MEMORANDUM

DATE: August 26, 2022

SUBJECT: **On-Call Contract #17-067H-1; PO # 8115428**
Traffic Impact Study Reviews
Task Order #3: Flying Horse North Sketch Plan TIS - 2nd Review

SHEET
SP.1

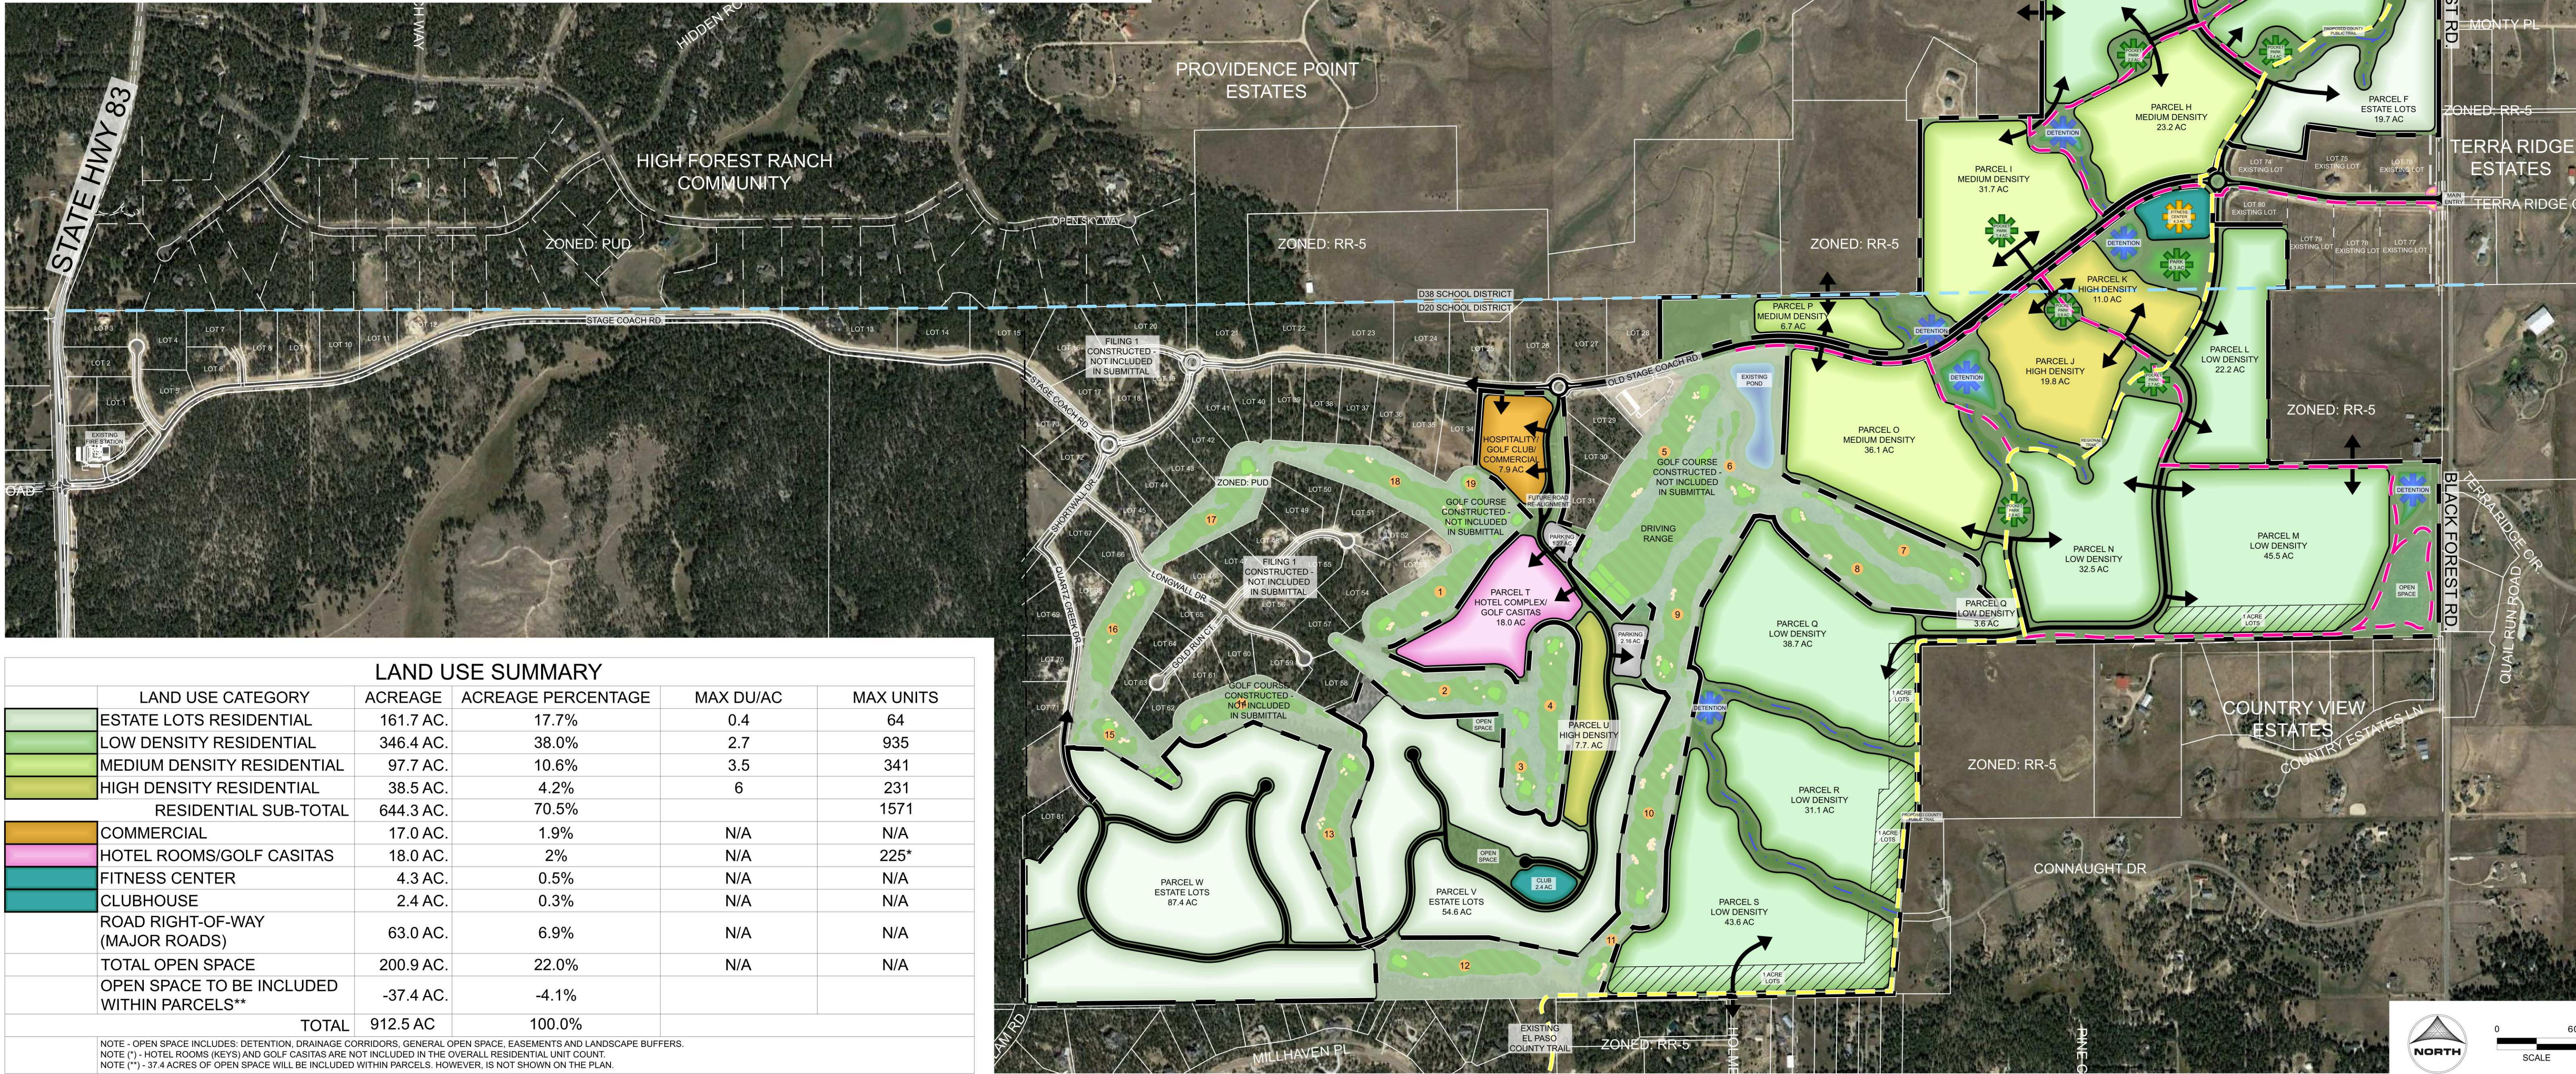
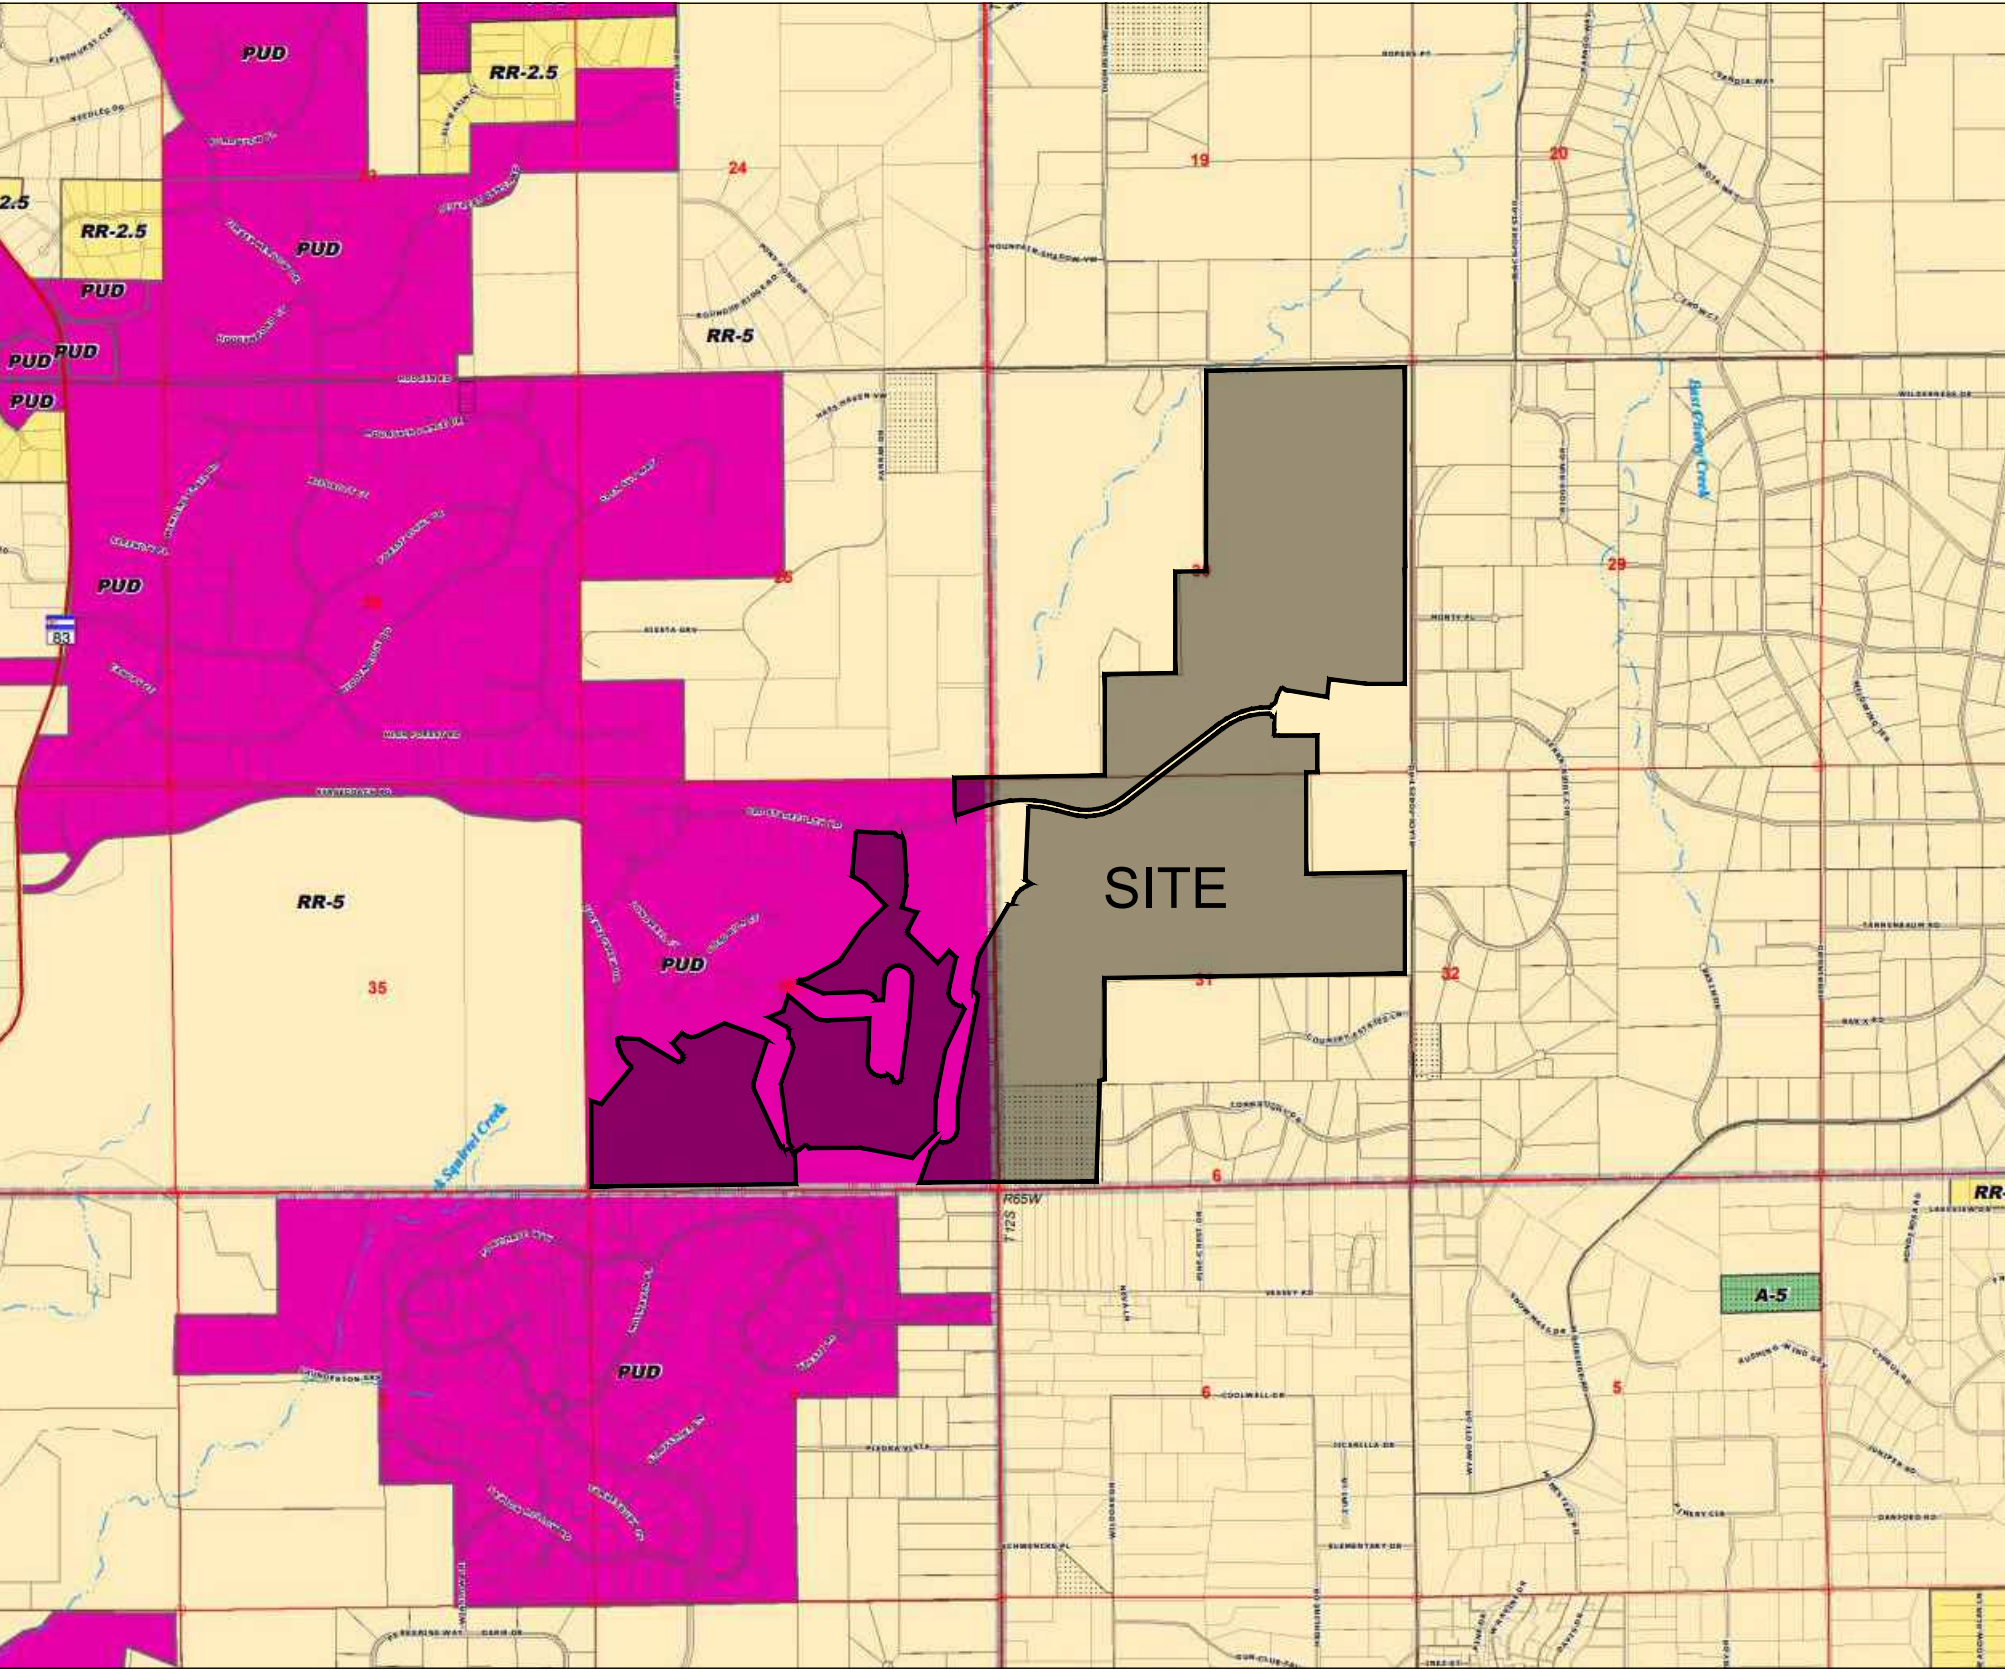
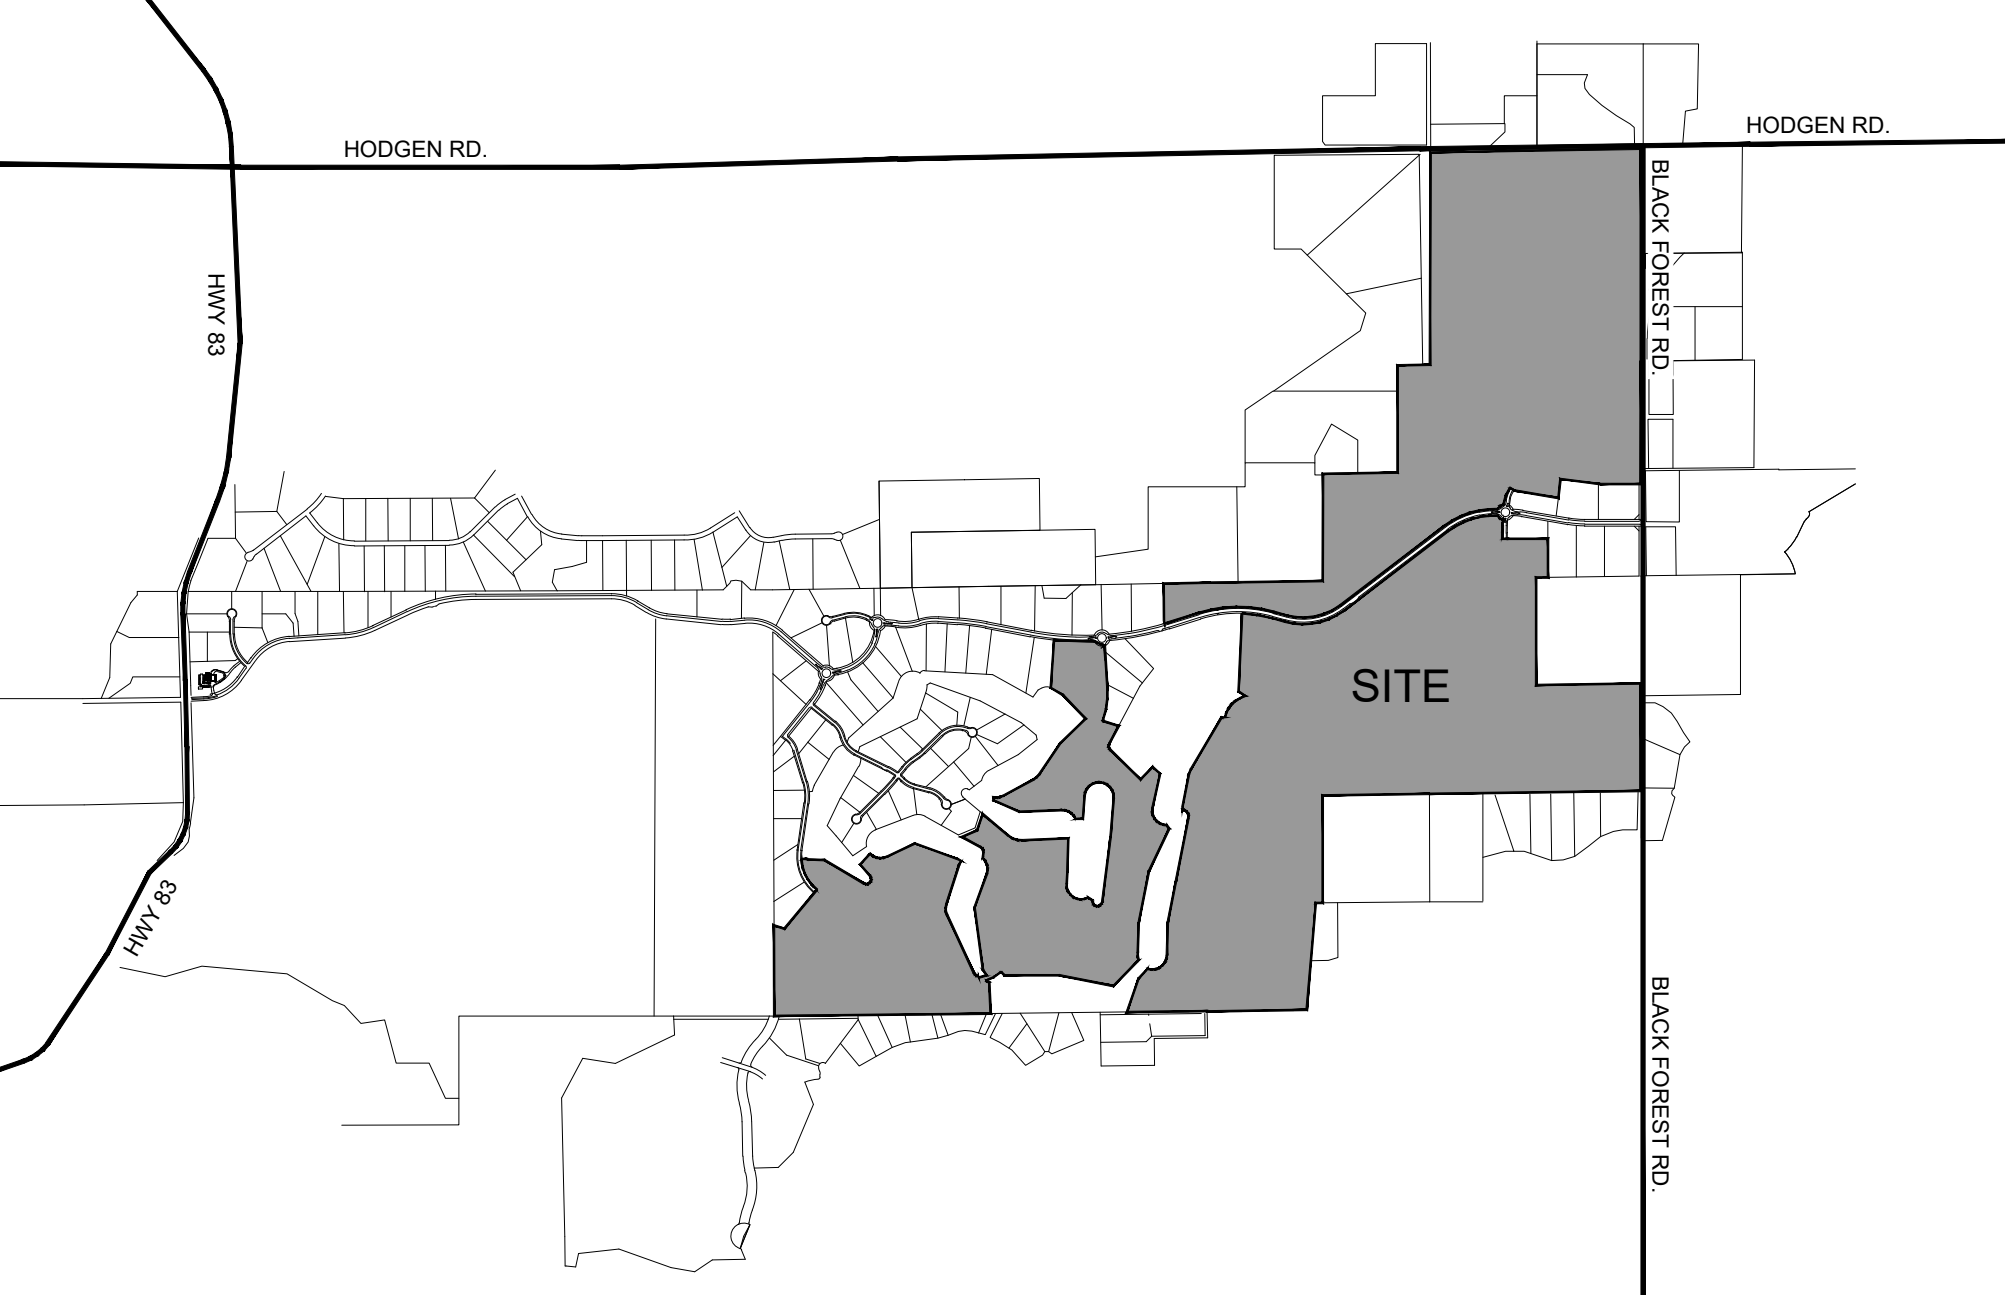
- General Note 1 on Sheet 1 refers to 1,471 DU while the remaining sketch plan sheets have been revised to show 1,121 dwelling units. Clarify.
- *The references to City of Colorado Springs requirements have been clarified.*
